**Subject: Request for Modification and Renewal of the Section 404 Individual Permit and Section 401 Individual Water Quality Certification, and Catawba Riparian Buffer Authorization** for the Widening of NC 150 from the NC 16 Bypass in Catawba County to just west of the US 21/NC 150 Interchange in Iredell County, including the Interchange with I-77. Federal Aid Project No. STP-150(19), Division 12, TIP No. R-2307 and I-5717.

**References:** 1) Section 404 Individual Permit, Action ID No. SAW-2018-02343, issued September 3, 2020;  
2) Section 401 Individual Water Quality Certification and Catawba Riparian Buffer Authorization, NCDWR Project No. 20181732, issued April 17, 2019

The purpose of this letter is to request renewal of the existing U. S. Army Corps of Engineers (USACE) Section 404 Individual Permit and N.C. Division of Water Resources (NCDWR) Section 401 Water Quality Certification (WQC) and Catawba Riparian Buffer Authorization.

PERMIT DRAWING
SHEET 7 OF 22

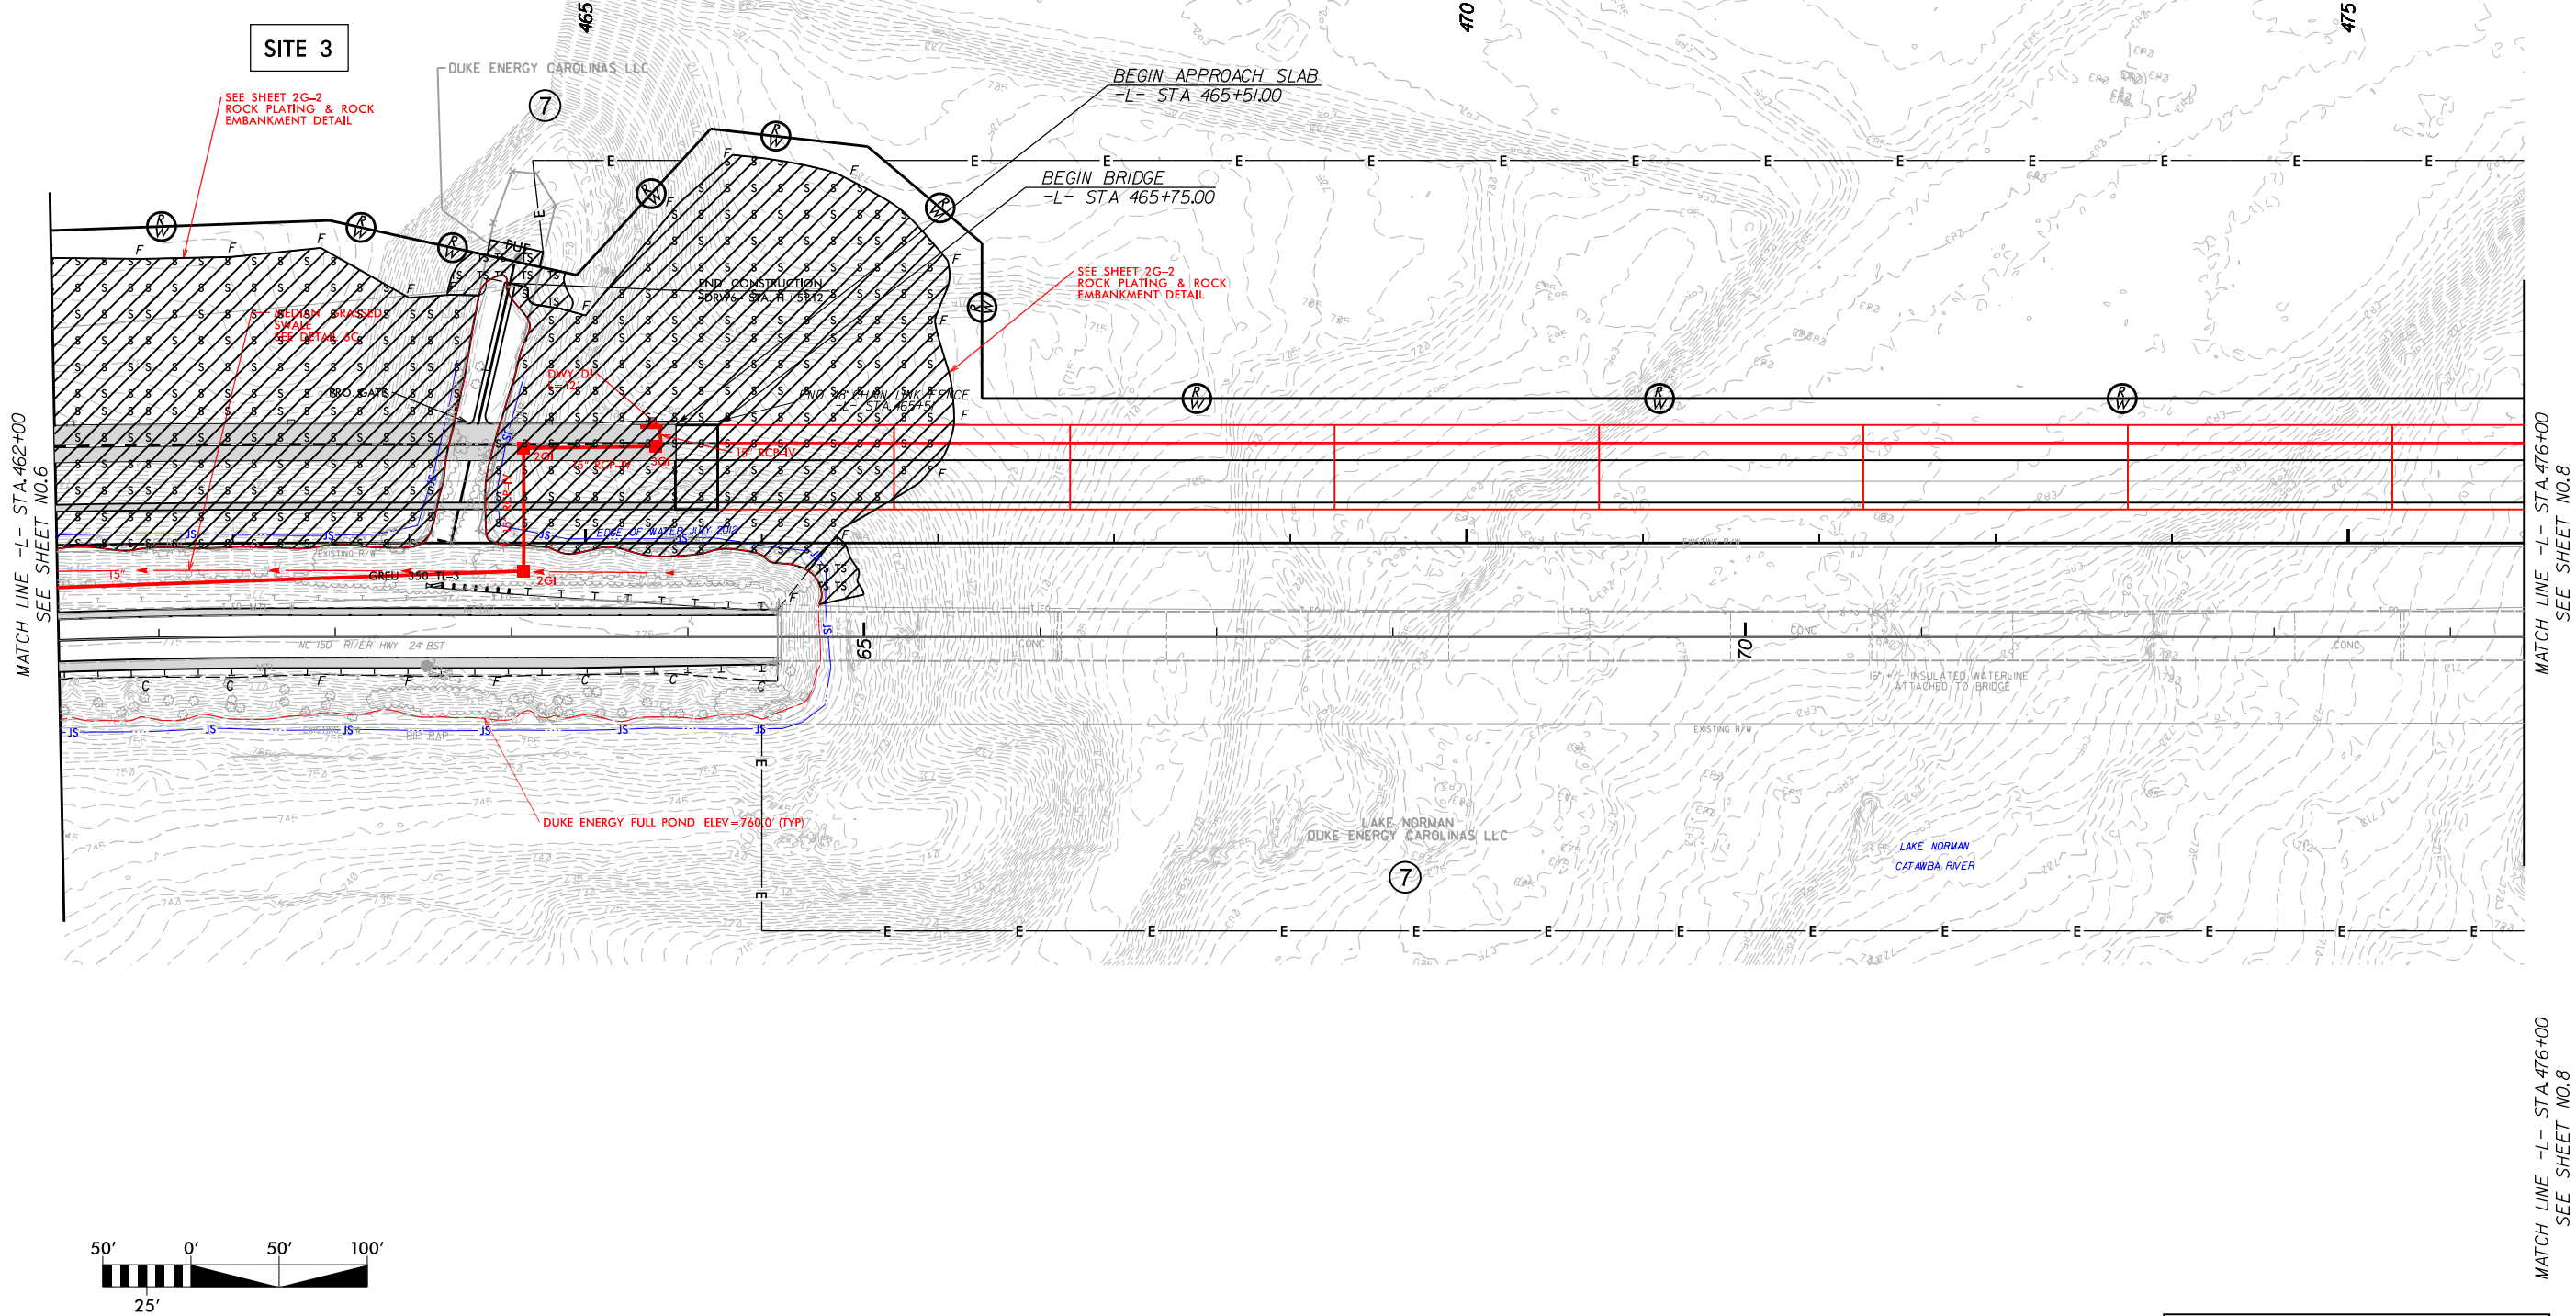
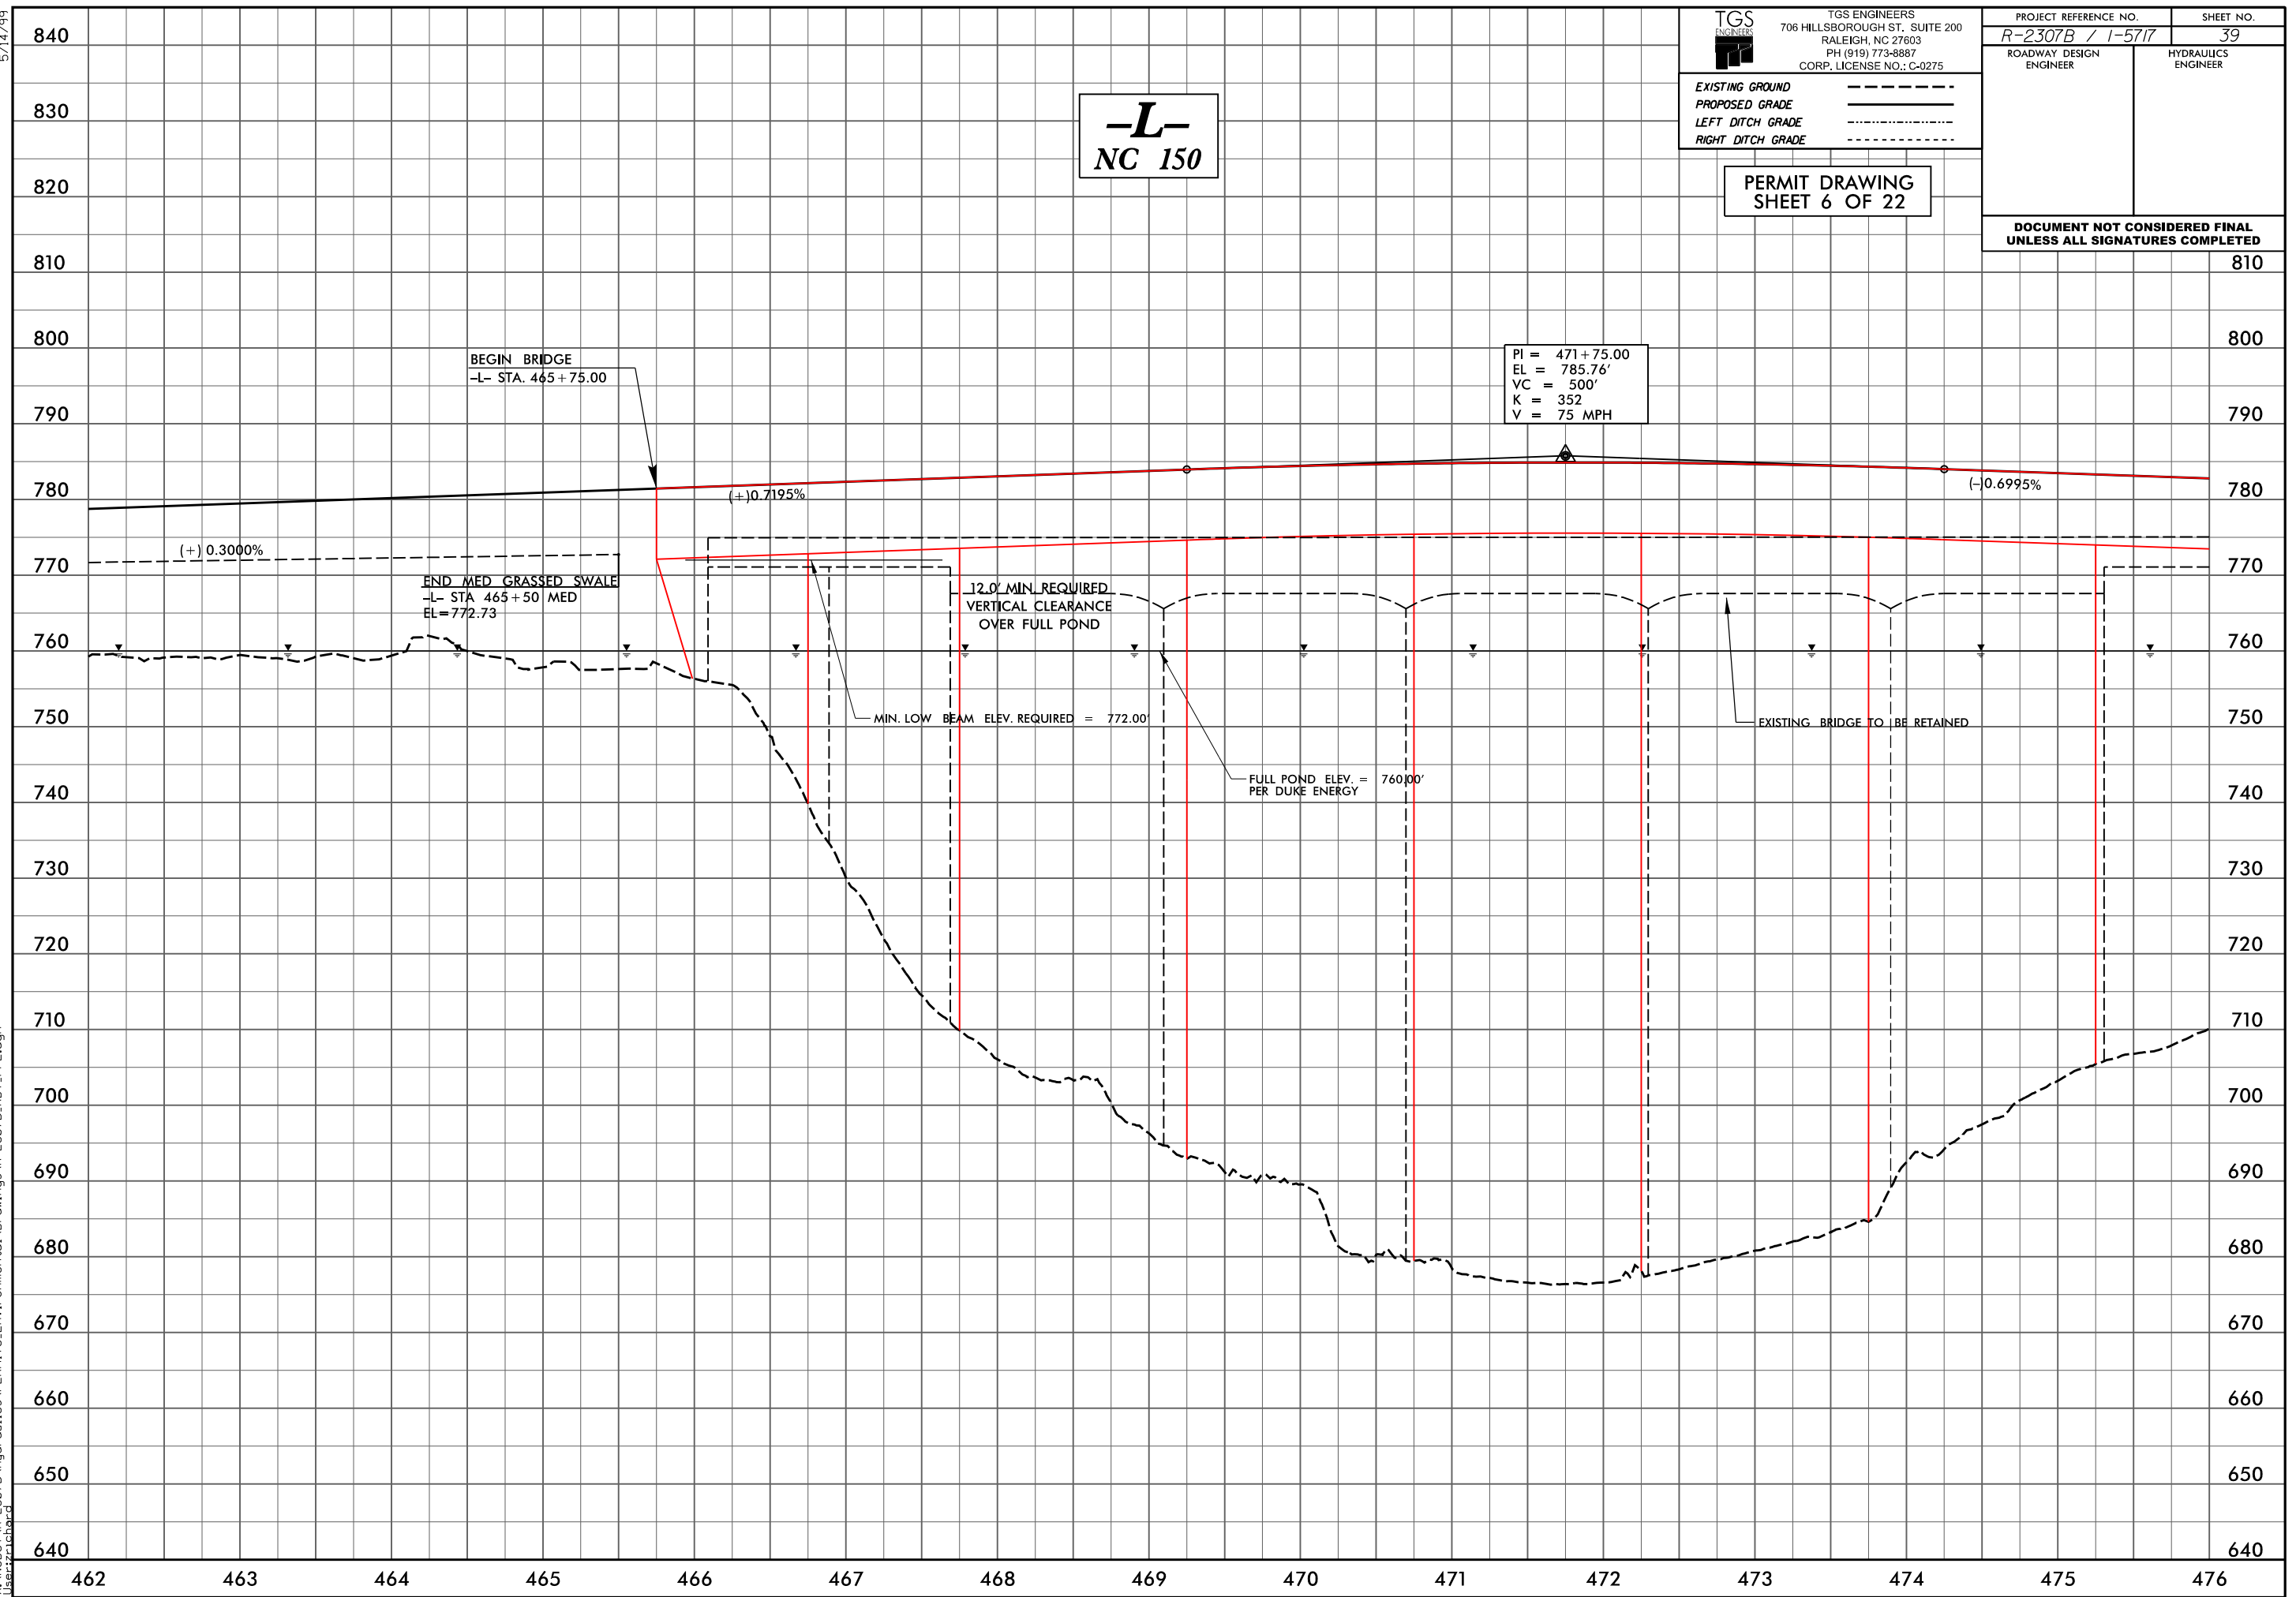
4. Site 4: Permanent Surface Water Impacts decreased from 3.91 acres to 3.859 acres due to minor slope changes at Lake Norman.
5. Site 4: Two temporary Surface Water Impacts were added down to elevation 750 ft on Permit Drawing Sheets 7-8. Temporary Surface Water Impacts increased from 0 to 0.162 acre.
